T-Bone Construction, Inc.
1310 Ford St.
Colorado Springs, CO 80915
(719) 570-1456 Fax (719) 591-5217

Letter of Intent:

Shops at McLaughlin II
7368 McLaughlin Rd.
Peyton, Co. 80831

1 of 10 SITE  
PLAN

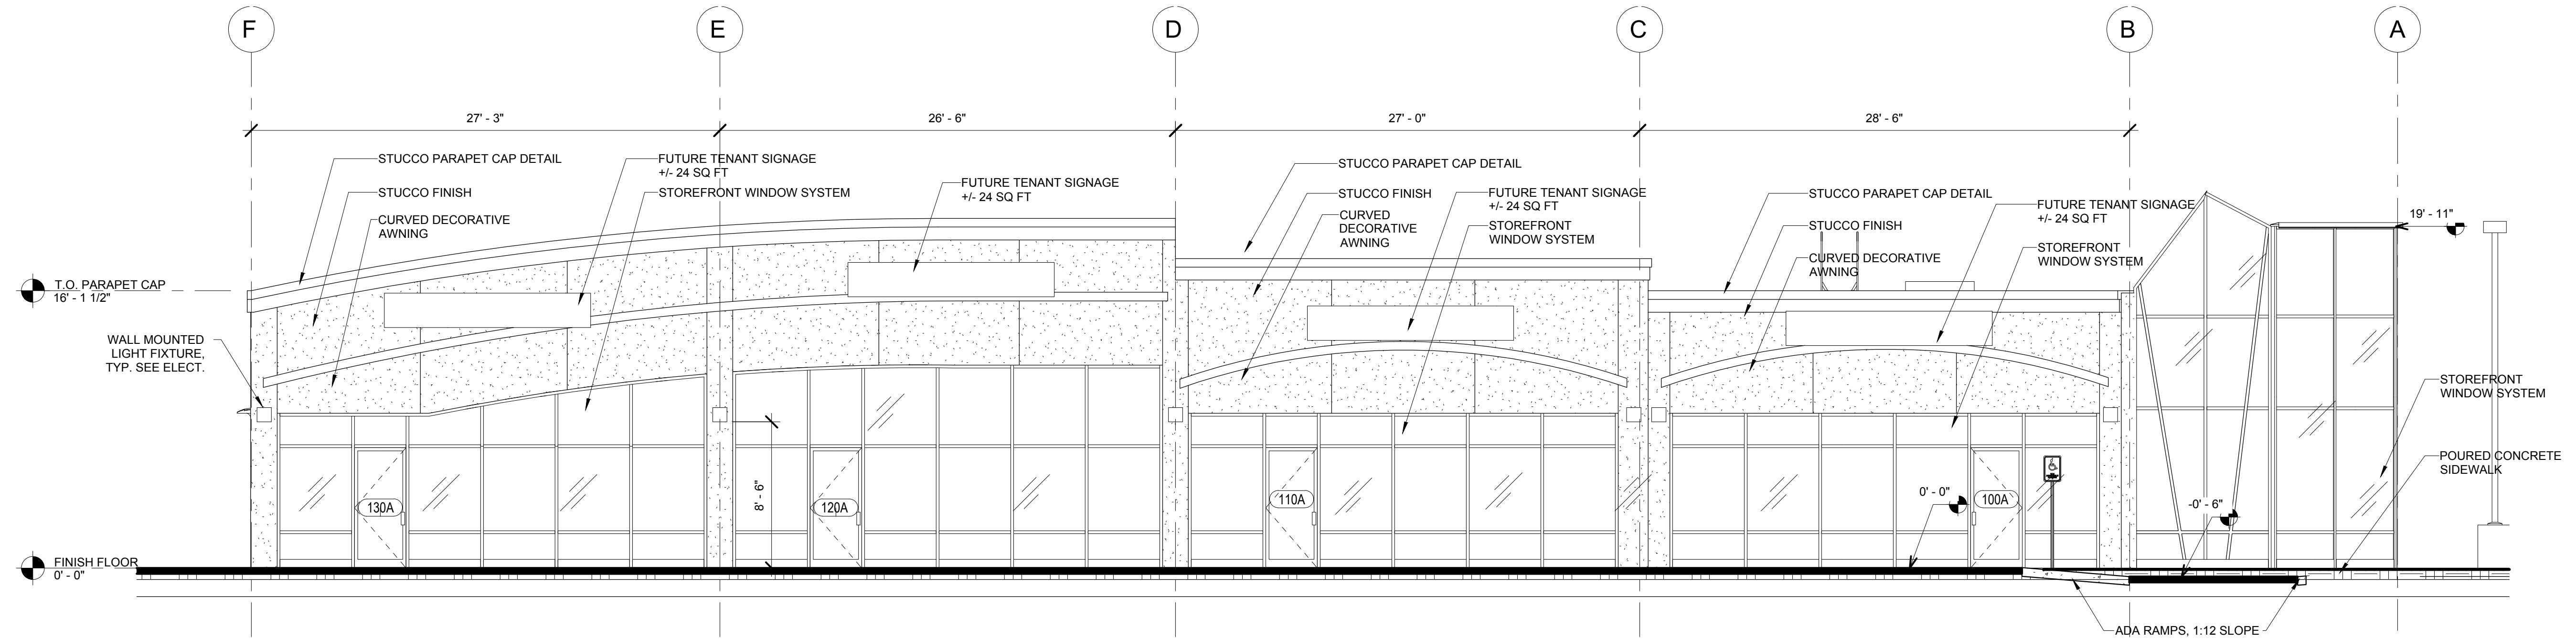
Parking is insufficient for intended use, if a request for a parking modification is needed, it must be present in the LOI, or a reduction in building size will be required. Also, the LOI needs to state, at no time will a restaurant be located on property, unless adequate parking can be present at 1 parking space for every 100 square feet of building space.
